10 February 2023

**SSD-31822612: Alterations and Additions to Barker College  
Written Submission on behalf of Catholic Schools Broken Bay**

Figure 7.10: Roundabout Concept at Clarke Rd and Malsbury Road

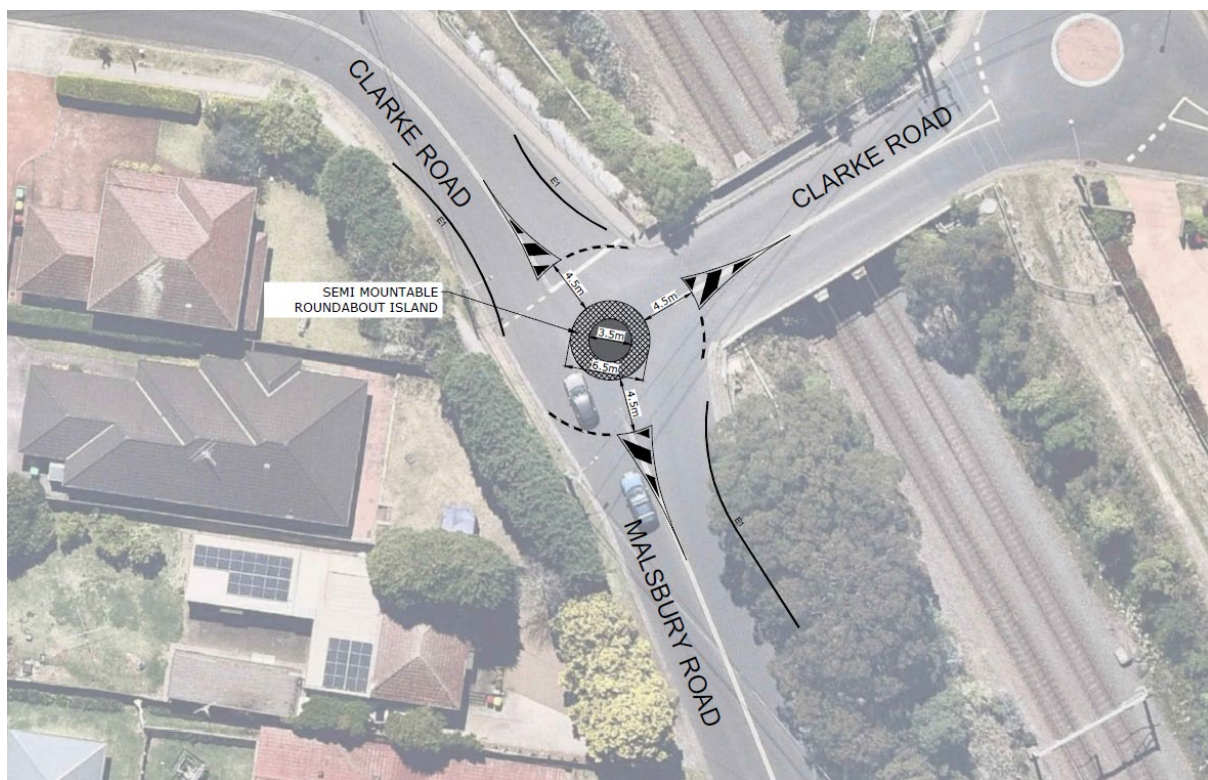
Another mitigation measure identified included the conversion of the intersection into a controlled roundabout at Malsbury Road and Clarke Road intersection.

There is overall concern that the recommended mitigation measures to minimise traffic impacts generated by the proposal relies on changes to the road network are only recommendations and are not committed with Council or Transport for NSW.
